PCU034088

21 May 2012

Parramatta Council submission on NWRL EIS

The aerial photos should have been clearer by showing more street names and LGA boundaries.

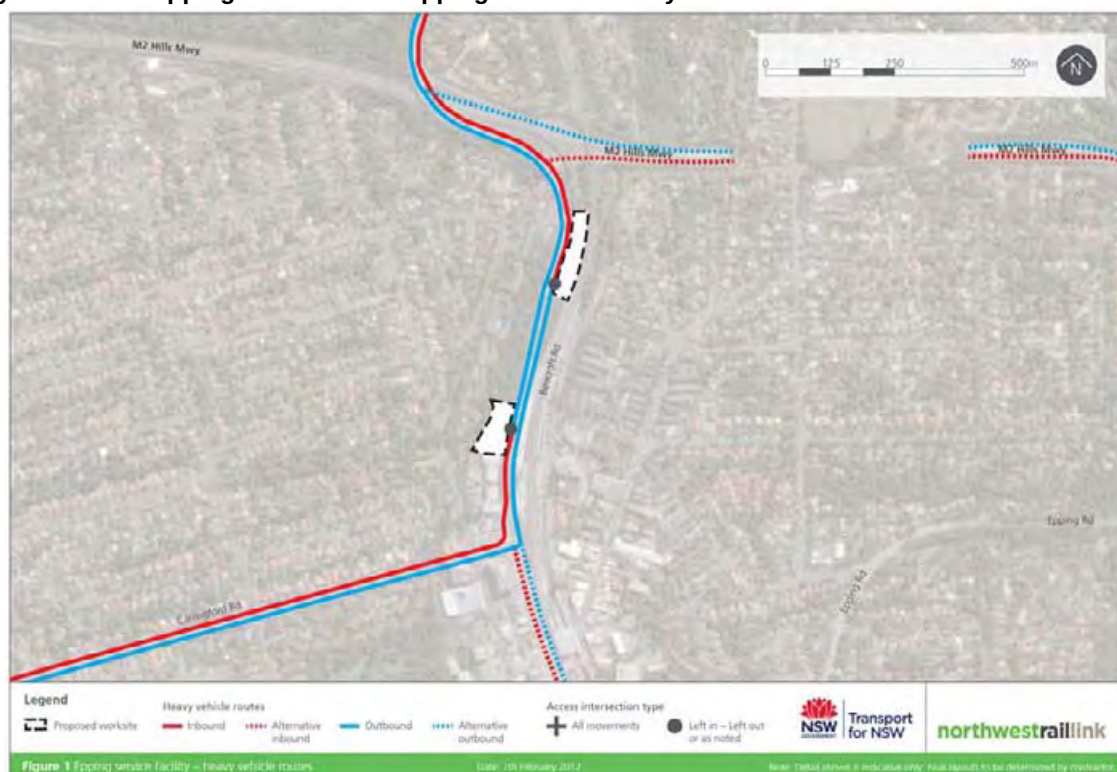
The construction sites on Beecroft Road, north of Carlingford Road are predicted to generate 50 vehicles per hour. This traffic would use the intersection of Carlingford Road and Beecroft Road, which is already at capacity in peak periods. Approximately half the traffic would make the right turn from Beecroft Road into Carlingford Road.

It is recommended that the project include the widening of Beecroft Road to allow the extension of the right turn bay from Beecroft Road into Carlingford Road (to at least 100m in length). The widening should also include a third lane southbound in Beecroft Road for a distance of at least 100m approaching Carlingford Road.
